**WEST SUSSEX COUNTY COUNCIL
STRATEGIC PLANNING CONSULTATION**

SUBJECT: LU/234/16/RES - Application for reserved matters relating to access, appearance, landscaping, layout and scale of the previously approved LU/63/11/. This application affects a Public Right of Way.

LOCATION: Fitzalan Link Road, Worthing Rd (A259), East Street, Littlehampton, West Sussex.

This is the fourth WSCC highways and transport response to the application seeking approval of reserved matters. Comments made below follow consideration of additional information provided in email from the applicant (Laura Graham of Persimmon Homes to Hilary Kernohan, Clare Potts and Tim Townsend) dated 30th November 2016. The text below should also be read alongside previous WSCC highways responses dated 21st September, 21st October and 21st November 2016.

| drawing number | PHF-MB-S278-GF-DR-D-PROW-01 | rev.     |             |            |    |

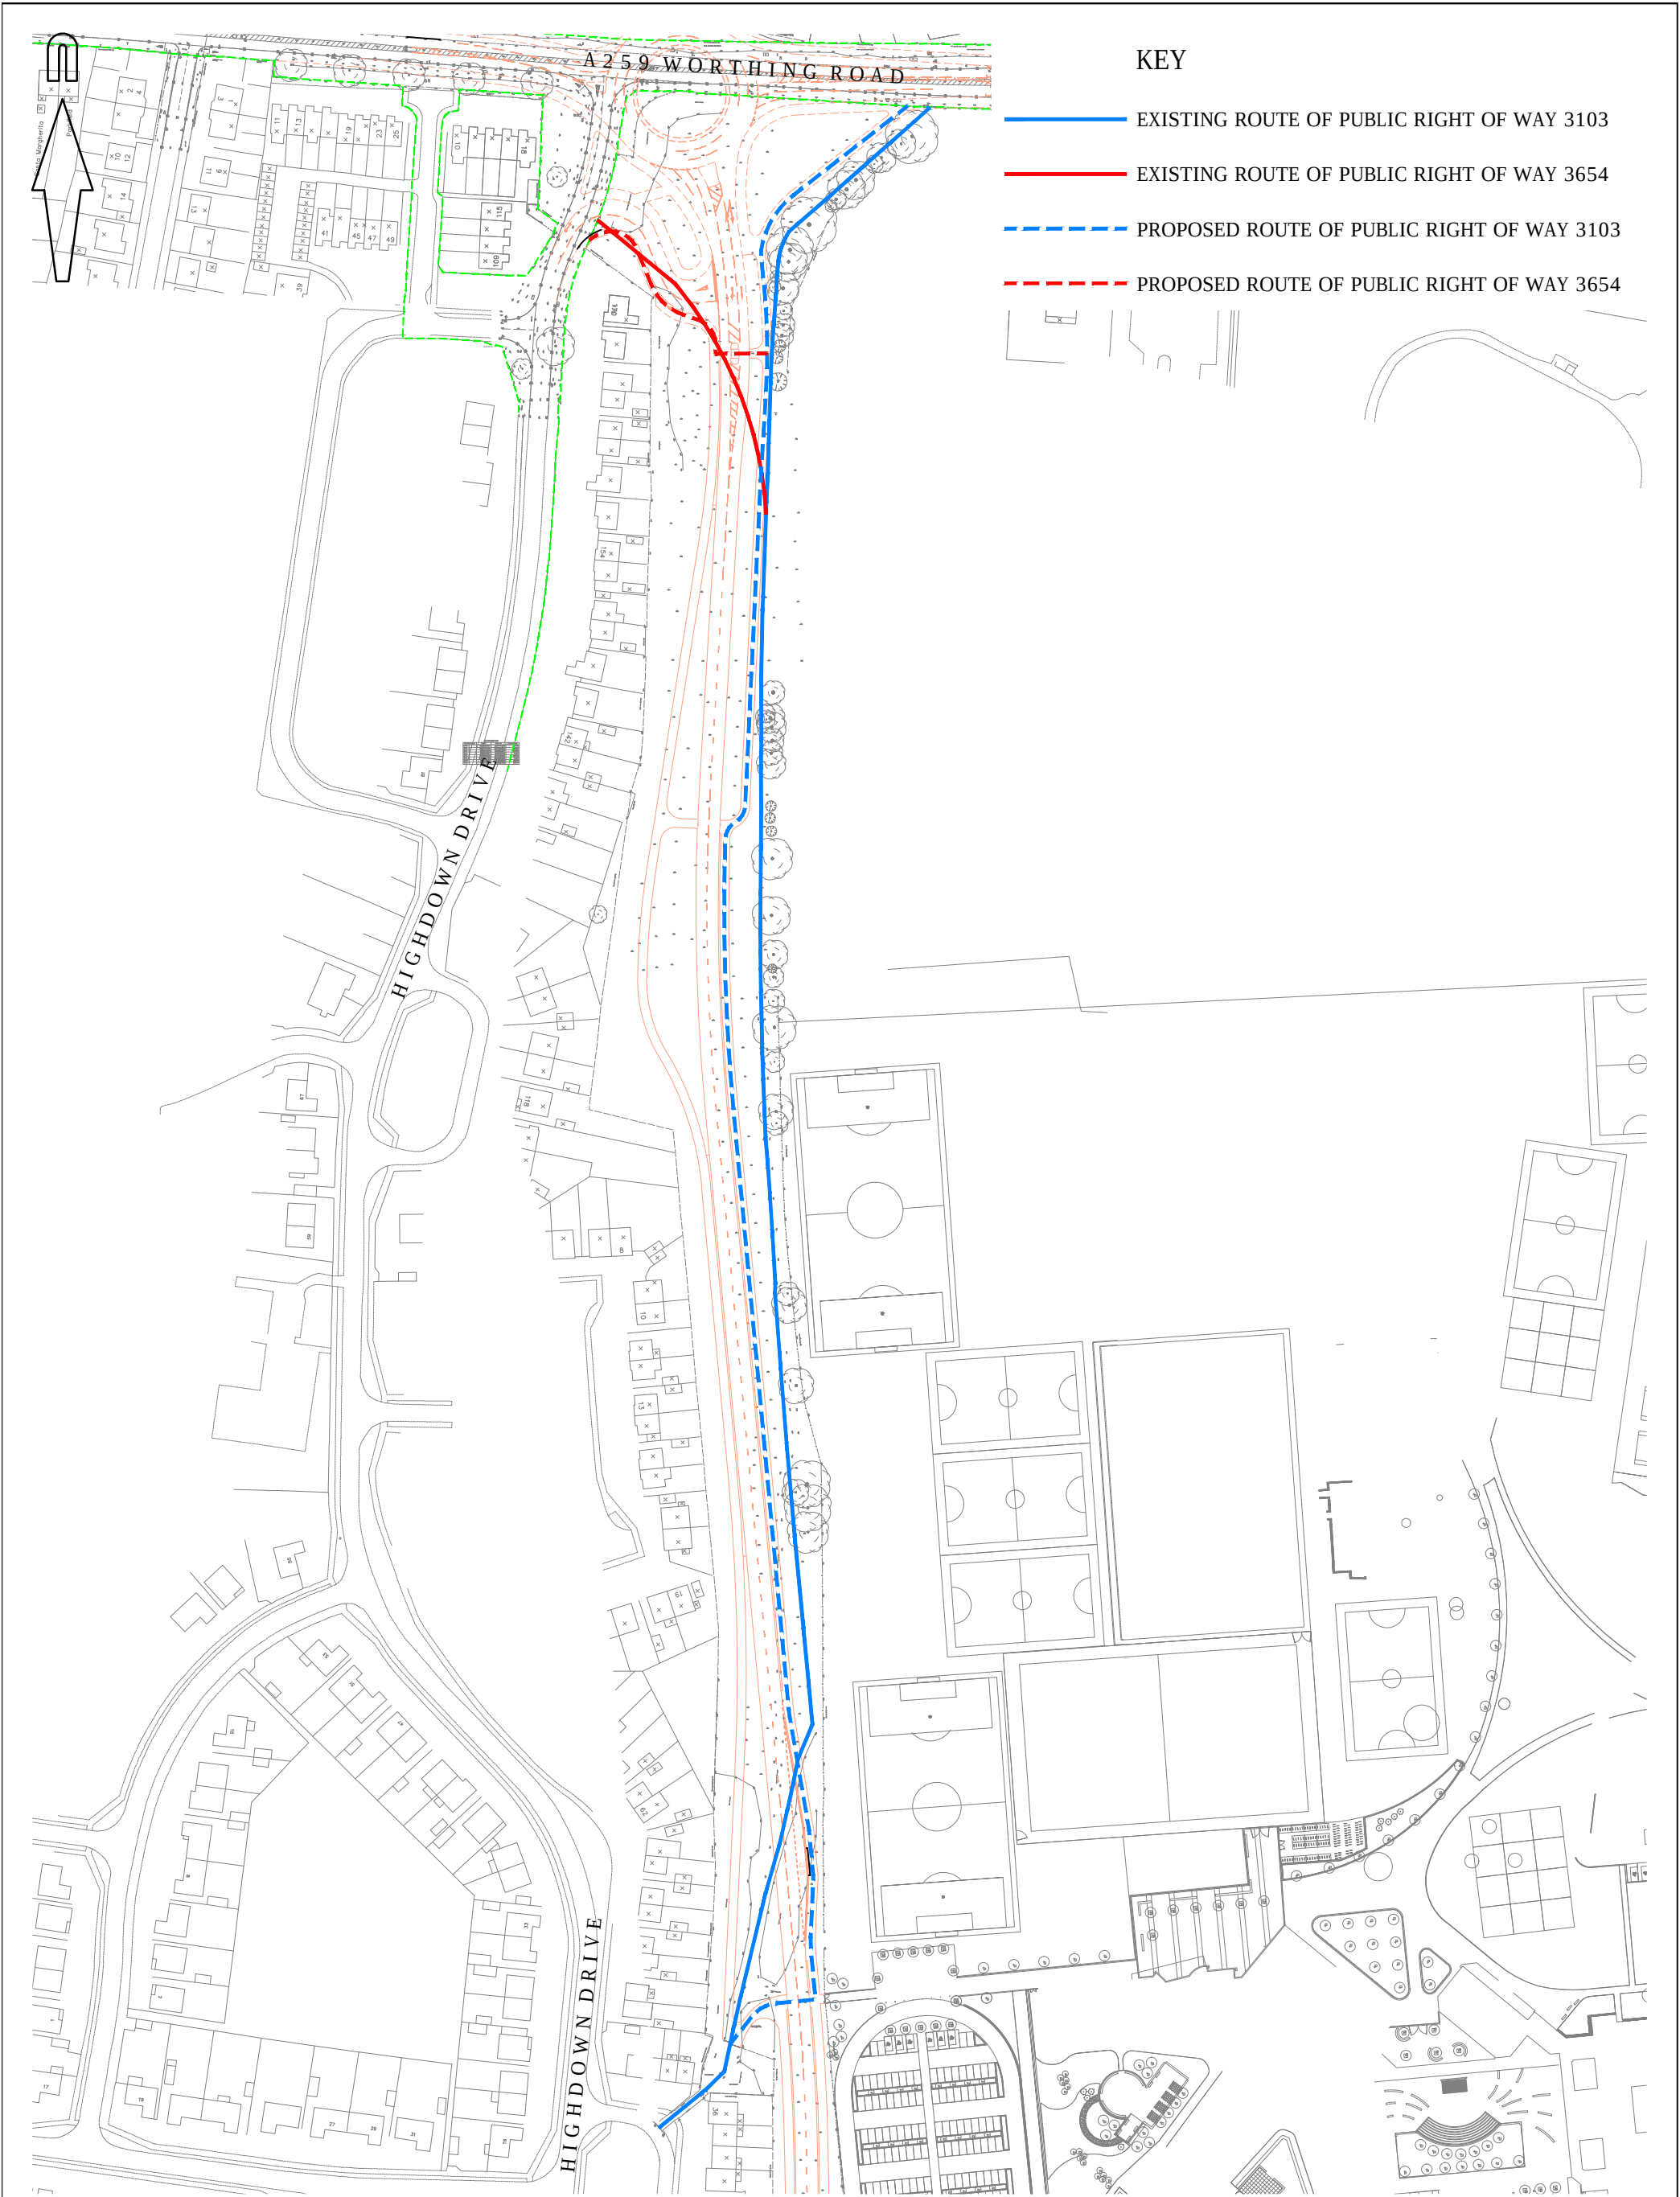
1. Red line boundary – This has implications for PRow connection in south-western corner (north of Academy roundabout) – please demonstrate that an appropriate design can be accommodated and correctly interact with existing PRow connection. As shown, the existing path and the new paths do not appear to tie-in. Also see 3 below. **Further information and alterations required.**

3. Shared footpath/cycleways alongside both sides of the access road – On the western side at the point the PRow joins the scheme, the alignment is very convoluted and may not meet appropriate design standards. Please amend and remove bends etc. This also applies to the 'kink' on the eastern side of the road found further north. Also, because of the increased speed limit along the majority of the road, it is recommended that the footpath/cycleways be set-back from the edge of the carriageway by a minimum of 1.5m wherever possible. Also because of the speed limit, a signal controlled crossing should be provided in this location (Toucan). Any design should be Safety Audited before planning consent is issued. **Please provide amendments, Road Safety Audit and Designer's Response.**

With regard to the alignment of the section of shared footpath/cycleway adjacent to the PRow on the western side of the road, the applicant has not provided an adequate alignment. LTN2/08 (cycle infrastructure design) has minimum design radii of 25m for commuter routes and 15m for local access routes. The route running parallel to the new road should be designed as a commuter route, and links off it should be designed as local access routes. Forward visibility requirements are also 25m and 15m respectively. Please show on an amended plan.

Accepted. The full extent of the land required to implement the outline consented scheme has not been made available. As a result, the alignment of the shared footway/cycleway has been altered from that indicated at Outline Consent stage. The geometry of the facility has been revised to provide a more suitable design and continuity of the PRow within the constraints of the site limits. The proposed PRow ties into the existing PRow route at the red line. Please refer to amended drawings PHF-MB-S278-GF-DR-D-210-01 Rev P5 and PHF-MB-S278-GF-DR-D-PROW-01 Rev P3.

Accepted. The full extent of the land required to implement the outline consented scheme has not been made available. As a result, the alignment of the shared footway/cycleway has been altered from that indicated at Outline Consent stage. The geometry of the facility on the western side has been revised to provide a more suitable design and continuity of the PROW within the constraints of the site limits. The proposed PROW ties into the existing PROW route at the red line. Please refer to amended drawings PHF-MB-S278-GF-DR-D-210-01 Rev P5 and PHF-MB-S278-GF-DR-D-PROW-01 Rev P3.

The geometry of the eastern facility has been amended to provide a more suitable design as requested. Please refer to amended drawings PHF-MB-S278-GF-DR-D-210-02 Rev P5 and PHF-MB-S278-GF-DR-D-PROW-01 Rev P3.
